From: Hampel Philip
Sent: 15 April 2019 13:03
Cc: Beardsworth Robert; Development Control; Kerry BABINGTON (Kerry.Babington@HistoricEngland.org.uk); Goodyear James
Subject: Land To The North Of Castle Street And South-East Of Waterhouse Lane, Including Castle Buildings And The Earl De Grey Public House - 19/00333/FULL & 19/00334/LBC
Attachments: A63+Castle+Street_Scheme+Map-01.jpg; 6459 May 1944.jpg; 6459A May 1944.jpg; 6459B July 1952.jpg; 6459E exist April 1996.jpg; 6459E Prop March 1999.jpg; 6459M Feb 2003.jpg; EdeG-001.jpg

Application Number: 19/00333/FULL
Proposal: Application for full planning permission for the demolition and partial rebuilding of the Earl de Grey public house; erection of link extension to Castle Buildings and the Earl de Grey; external alterations to Castle Buildings; use of relocated Earl de Grey, Castle Buildings and link extension for café or restaurant (A3) and/or drinking establishment (A4) and/or office (B1a); the erection of a nine-storey hotel; new public realm and associated works, including landscaping, car parking and servicing, and associated infrastructure.
At: Land To The North Of Castle Street And South-East Of Waterhouse Lane, Including Ca

Fig 9: Earl de Grey Ground Floor Plan (approx. extent of listing in red)

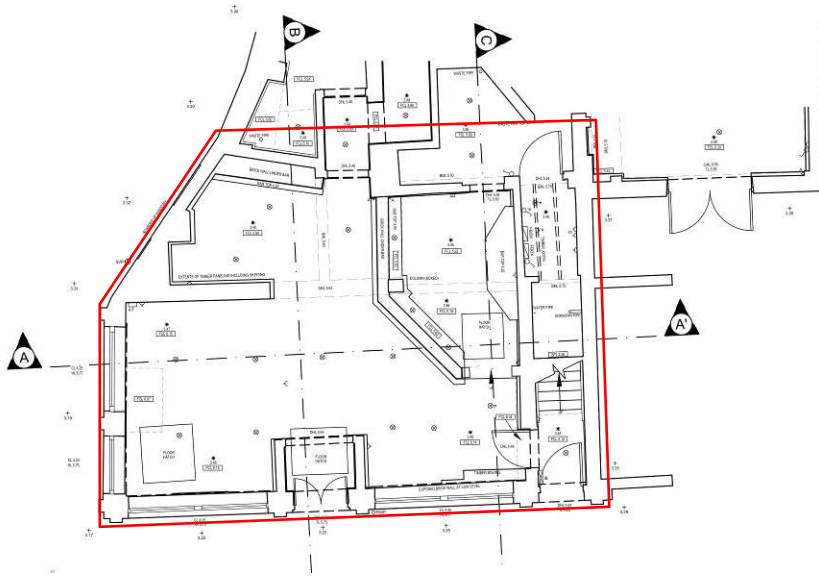
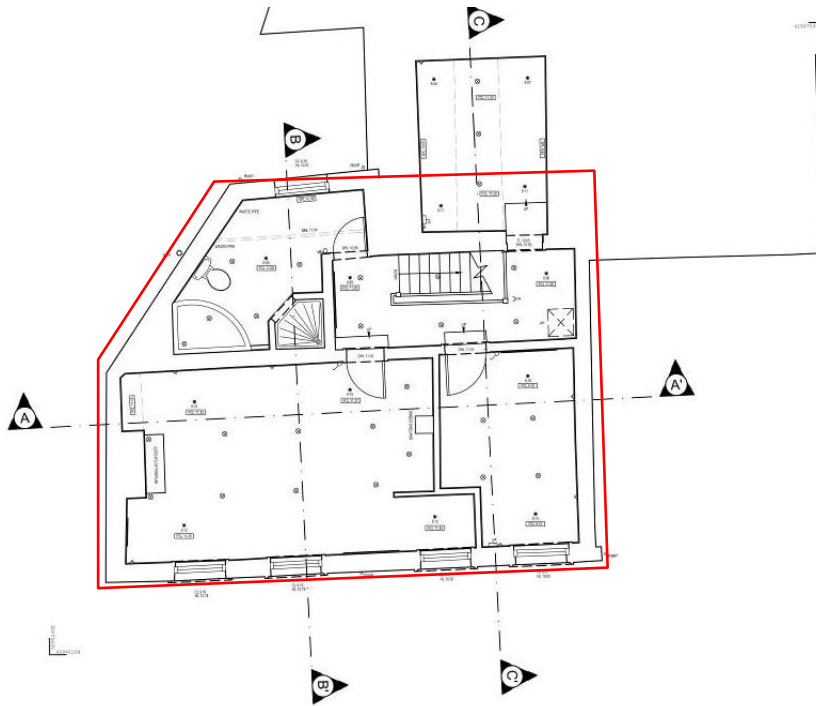
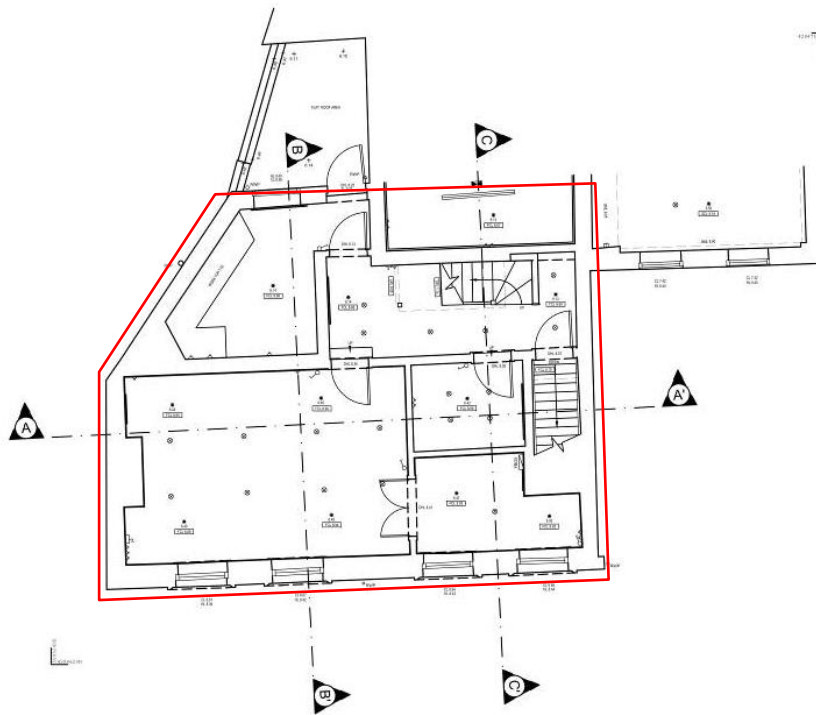
Although I am generally supportive of the proposal in relation to the Earl de Grey, I would strongly favour the pub being rebuilt on the same building line as Castle Buildings (at the back edge of pavement) and not set back in a subordinate manner as proposed. To maintain significance, the original plan form of the building must also still be legible. Therefore, any exterior walls with new knock throughs must maintain drop downs from the ceiling and wall end nibs. New features, such as the stairwell, must not encroach into what was the public bar area. The main entrance doors must remain as double doors, not a single door as proposed. Side door must remain as a panelled

door. Proposed chimney stack is too squat and not as existing. First and second floor fenestration pattern is not as existing and must be amended accordingly.
